**Heyford Park, Camp Road, Upper Heyford,  
Bicester, OX25 5HD**

**23/01959/NMA**

**Proposal:** Non-material amendment to 16/02446/F - amended elevation plans for 7 plots (plots 630-632, 634-635 & 646-647)

Drawing Title:  
**HOUSE TYPE 4A  
ELEVATIONS [BRICK]**

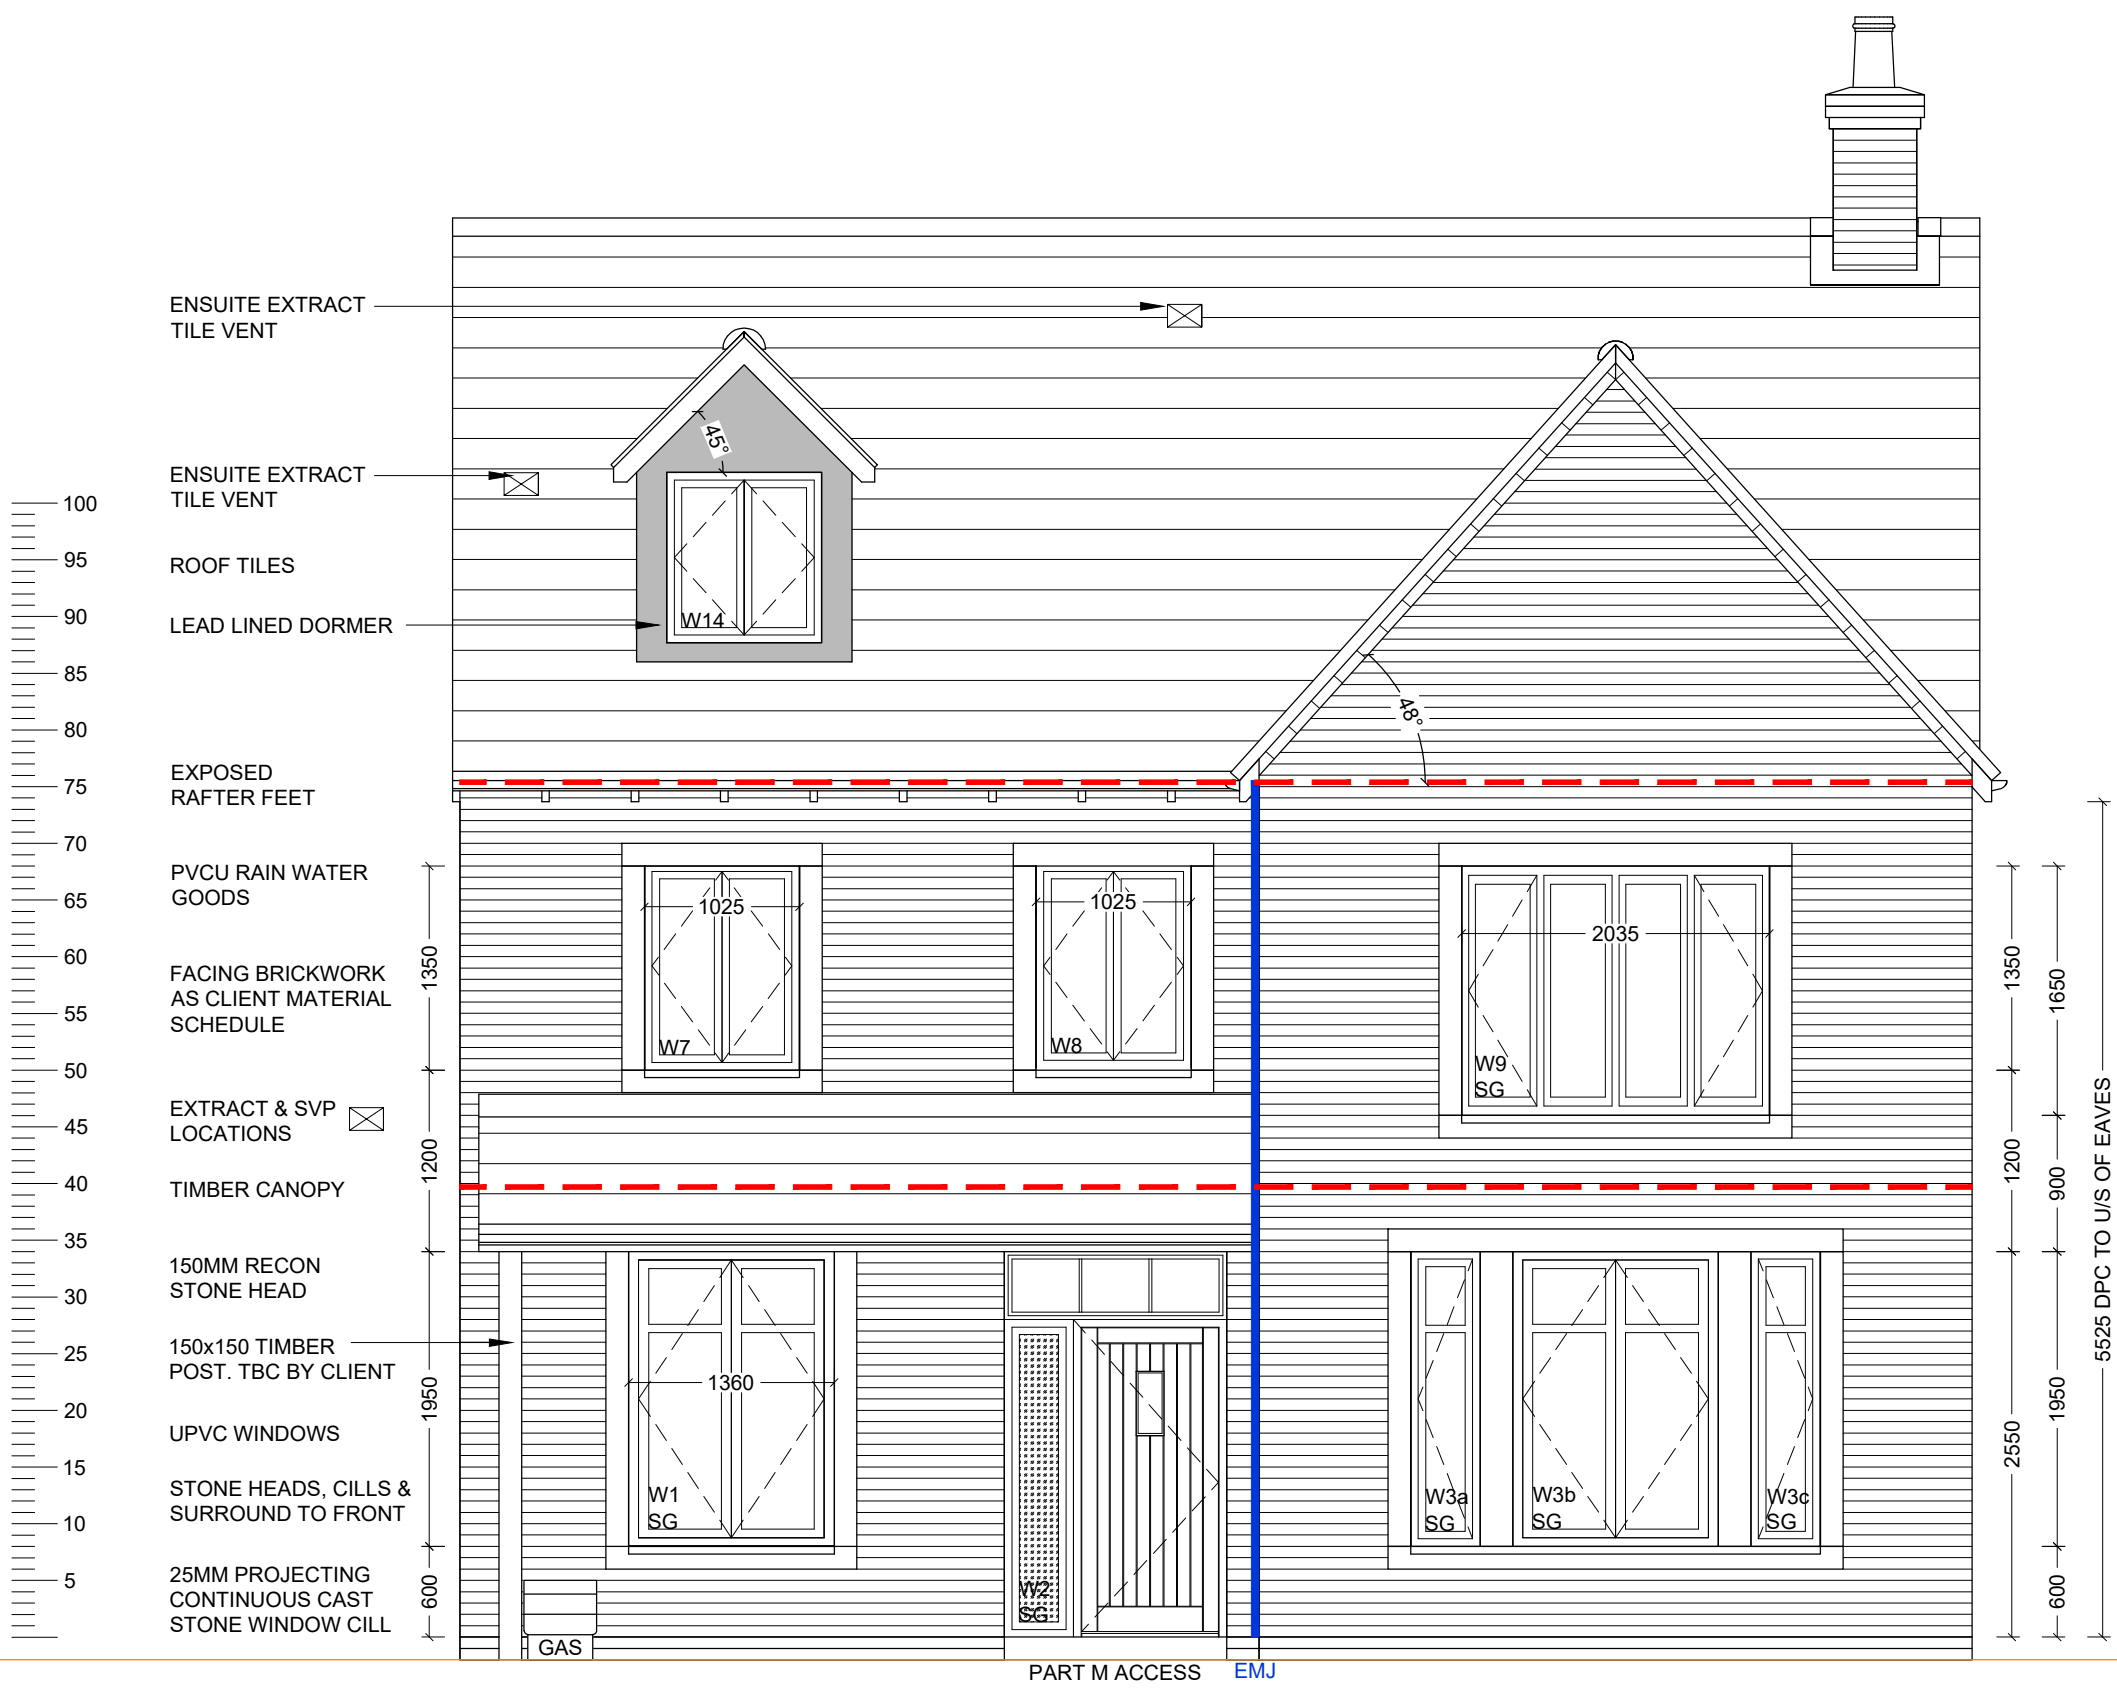
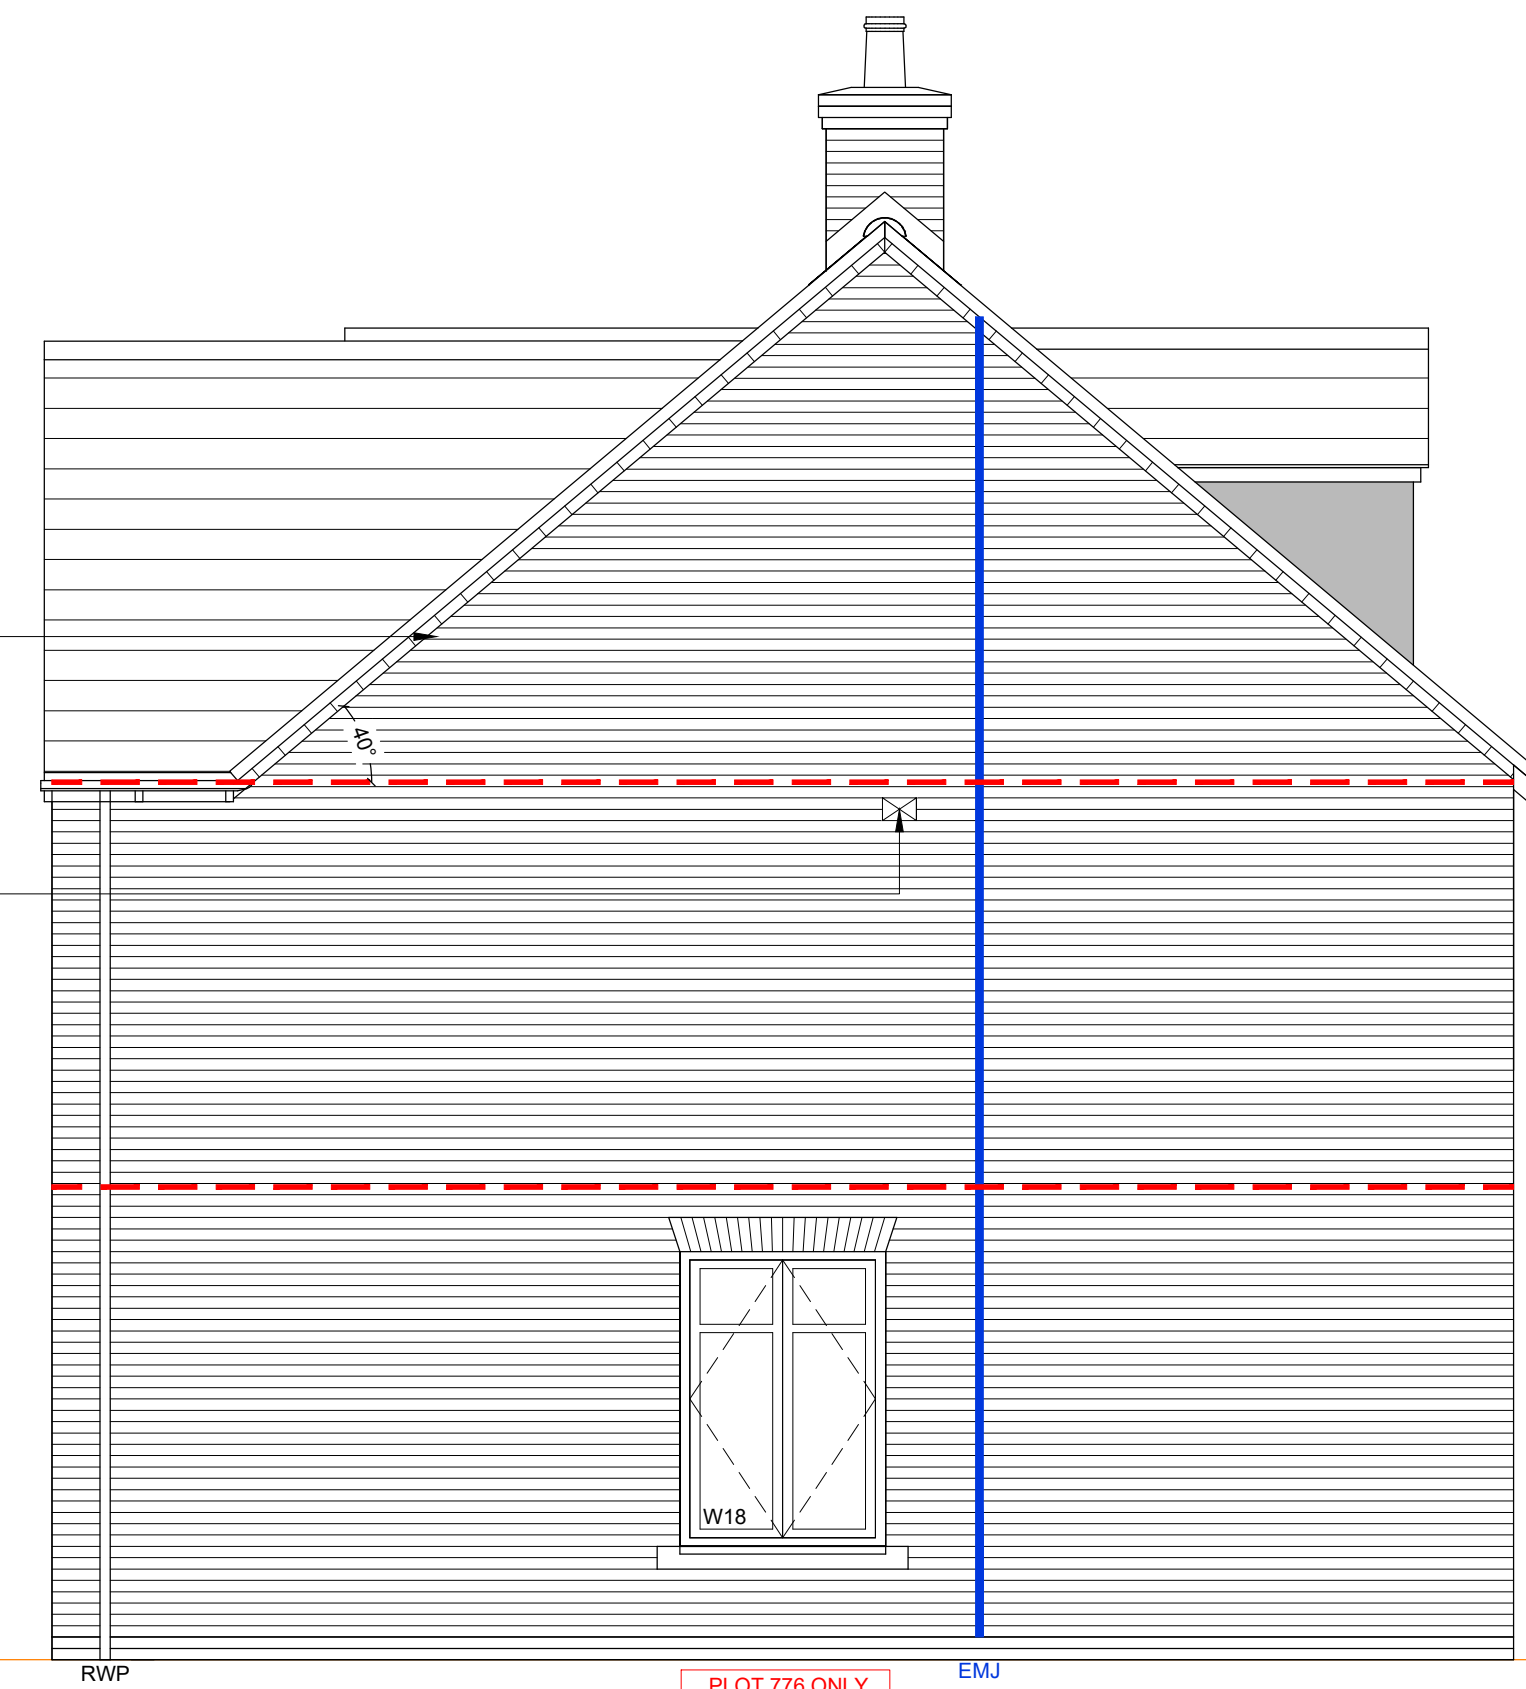
#### House Type 4A – Plot no.632

- Both render and brick elevations have stone surrounds added;
- Brick elevations have quoin detail added to front elevation corners;
- Render elevations have additional brick detailing to gable ends;
- 1st floor windows elongated.
